Date: **05-03-2020**
Our Ref: **15909**
Revision **0**

For the attention of: Geoff Walker
Project name: AHU Pressure Drops

Air handling units **AHU01**

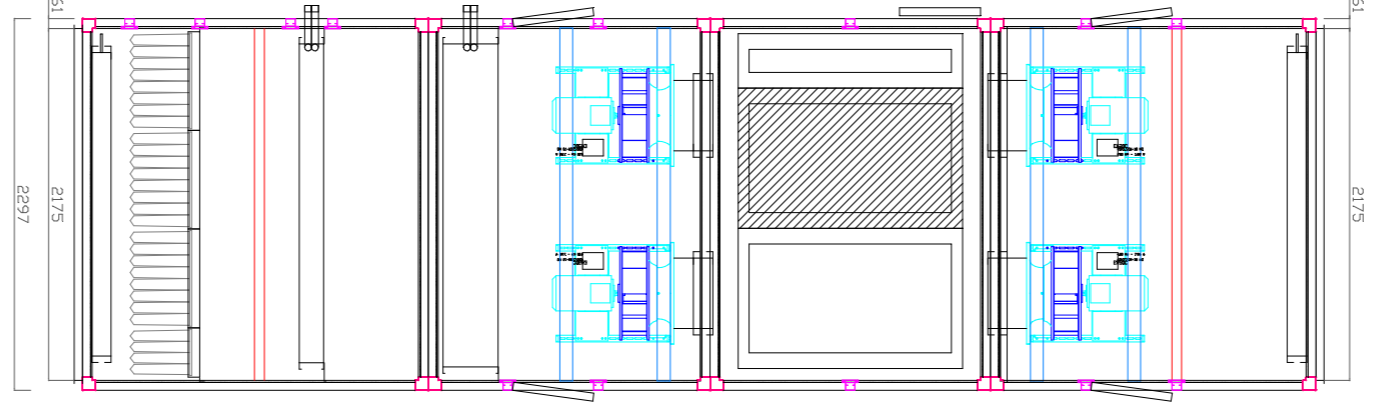
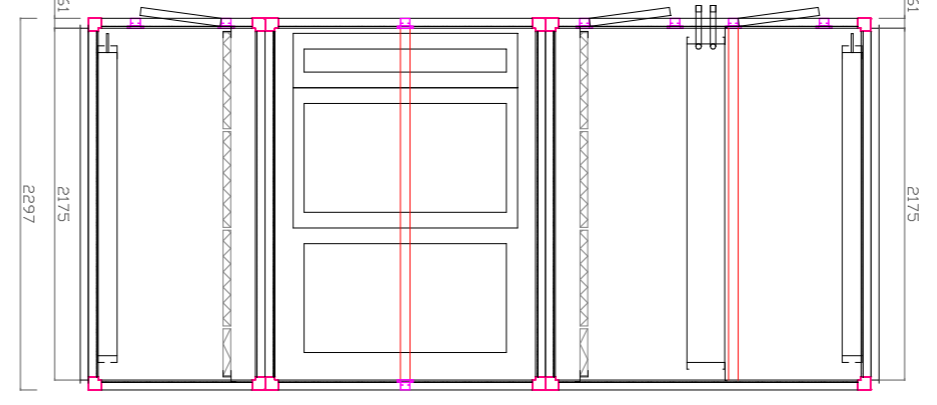
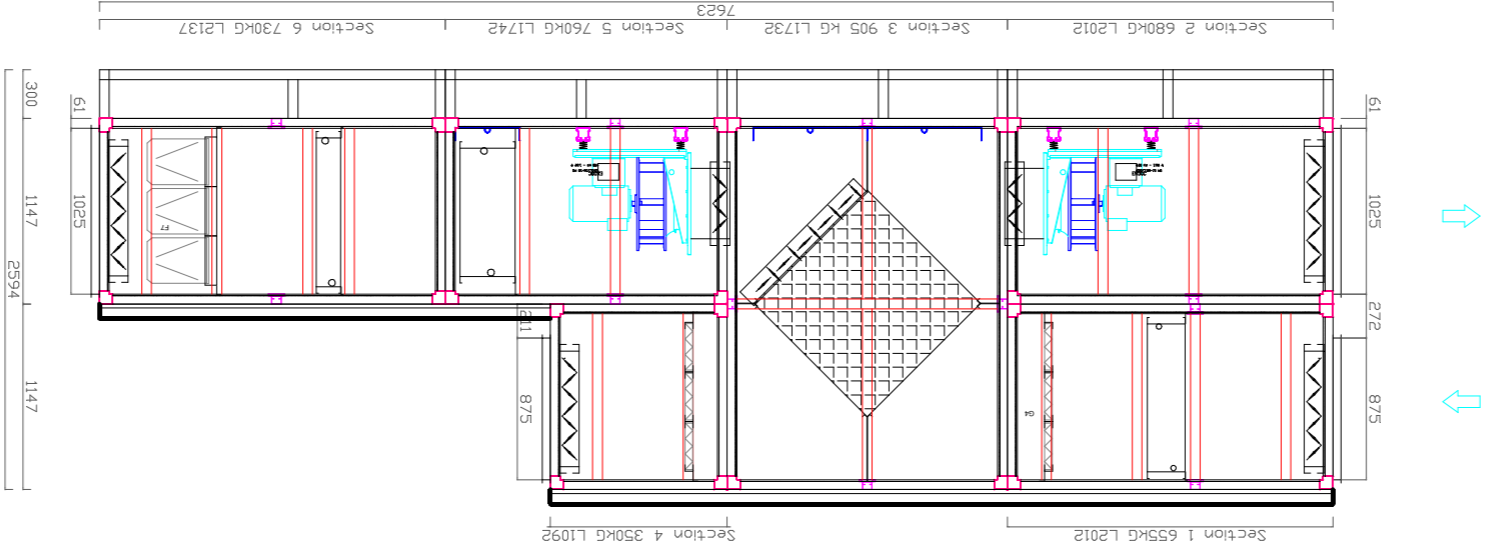
- The AHU should be arranged so that most items are under positive pressure. Any item of plant requiring a drain should be on the positive pressure side of the fans. Currently the fan positions place the drain trays in the PHE section under negative pressure.

- The plant and distribution system must not contain any material or substance that could cause or support combustion. It should be noted that : the droplet eliminator blades fitted to the cooling coil are PPTV, the standard dampers offered are fitted with polypropylene gear mechanism and TPE-V+PP blade seals, inspection windows offered are constructed from acrylic sheet with EPDM seals and the lighting cabling offered is wired in SY cabling with bulkhead light fixings of a clear prismatic diffuser and plastic base. All of these items are standard fitted items for a HTM AHU manufacturer but do not comply with HTM.

- Batteries that are significantly wider than 1m should be split to permit withdrawal from both sides.
